**PLANNING REF: AL/20/18/OUT – Land at Bridge Cottage and The Old Cottage
Lidsey Road**

**PRE-APPLICATION ADVICE COMMENTS FROM - HOUSING STRATEGY AND
ENABLING MANAGER – ARUN DISTRICT COUNCIL**

Figure 4.1 – Illustrative Site Plan

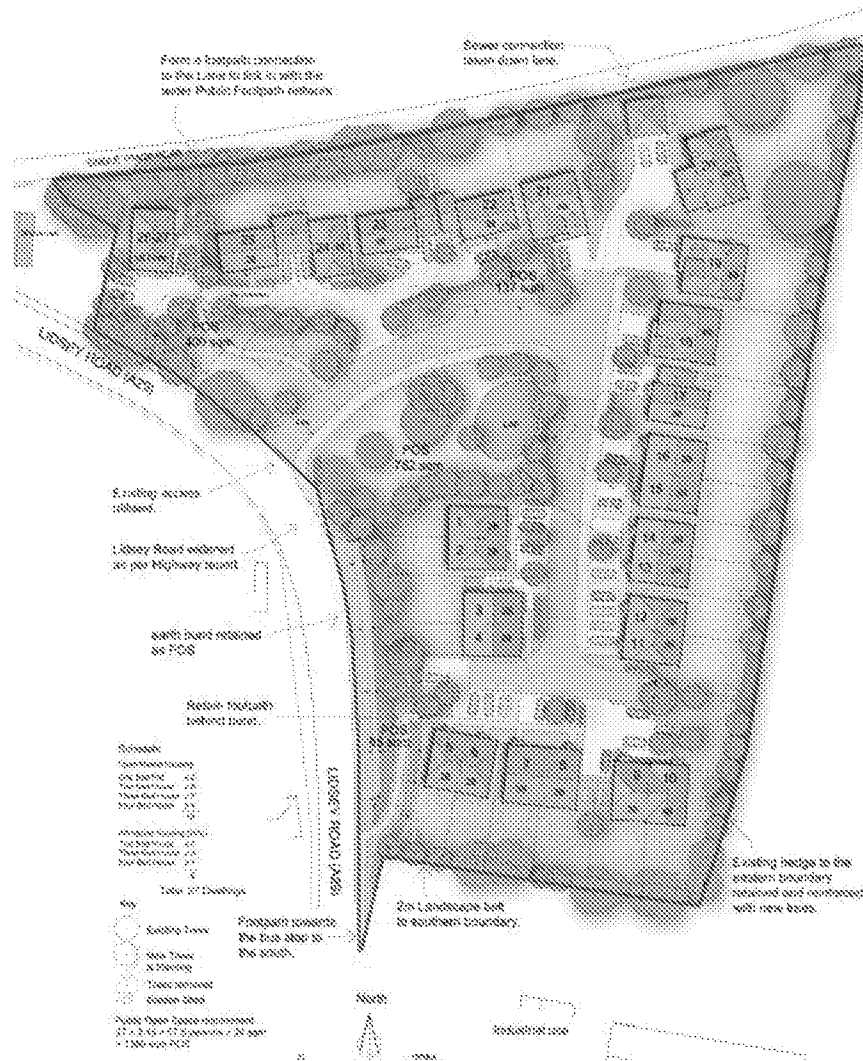
The proposed dwelling mix of 4 x 2 bed houses, 3 x 3 bed houses and 1 x 4 bed house does not adhere to this requirement.

Object. Whilst the quantum of affordable housing meets the council's policy requirements the proposed dwelling mix is not acceptable.
